From: Amy Myer <Amy.Myer@arun.gov.uk>
Sent: 12 January 2021 16:37
To: Planning.Responses <Planning.Responses@arun.gov.uk>
Subject: FW: Planning Consultation on: BR/292/20/PL - EH OBJECTION

PLs add below email to the case file online and label as 'EH Officer comments – noise impacts (request for revised/further info)'

With regard to the noise impact assessment (Butlin's Bognor Regis Temporary Venue Noise Impact Assessment, 002, November 2020 by Max Fordham LLP) Environmental Health would make the following comments:

Description of Works: Erection of temporary buildings to accommodate performance stage and seating for a period of up to 3 years. This site is in CIL Zone 4 (Zero Rated) as other development.

Figure 1: A site plan showing the site boundary of the Butlin's site in red, as well as the locations of the measurement positions, nearest noise sensitive receiver and the approximate location of the proposed venue. Imagery courtesy of Google.

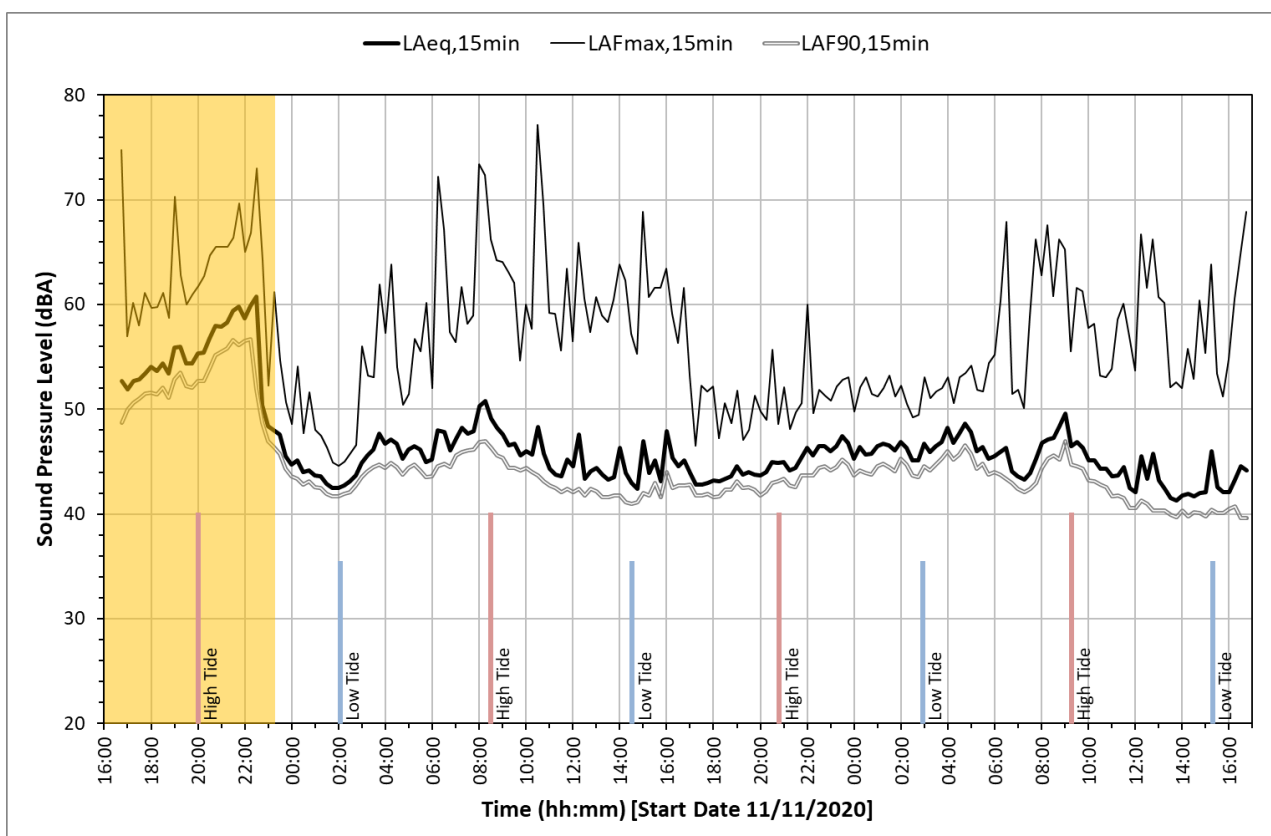
3. With regard to Section 3.1, Environmental Health has concerns that the survey location chosen by the applicant may not be entirely representative of the nearest noise sensitive residents. There is a block of flats on the corner of The Esplanade and Gloucester Road called Compass Point. These flats would be directly in the line of sight of the new venue, across the Gloucester Road Car Park. The survey location for the acoustic report is located slightly further north on Gloucester Road and it would appear that some shielding from the Atlantic Bay Apartments may occur (in terms of noise). Please could the applicant confirm whether or not these factors were taken into account during the noise survey, and provide any justification necessary?

4. The noise survey was conducted between 11th – 13th November 2020 during the second lockdown. Environmental Health agrees that the recorded figures are likely to not be representative of typical noise levels in this area. Further the noise survey was only undertaken between the Wednesday and the Friday and as such does not comprise a full 7 days. Environmental Health have concerns that weekend noise levels may be different and would not have been taken into account.
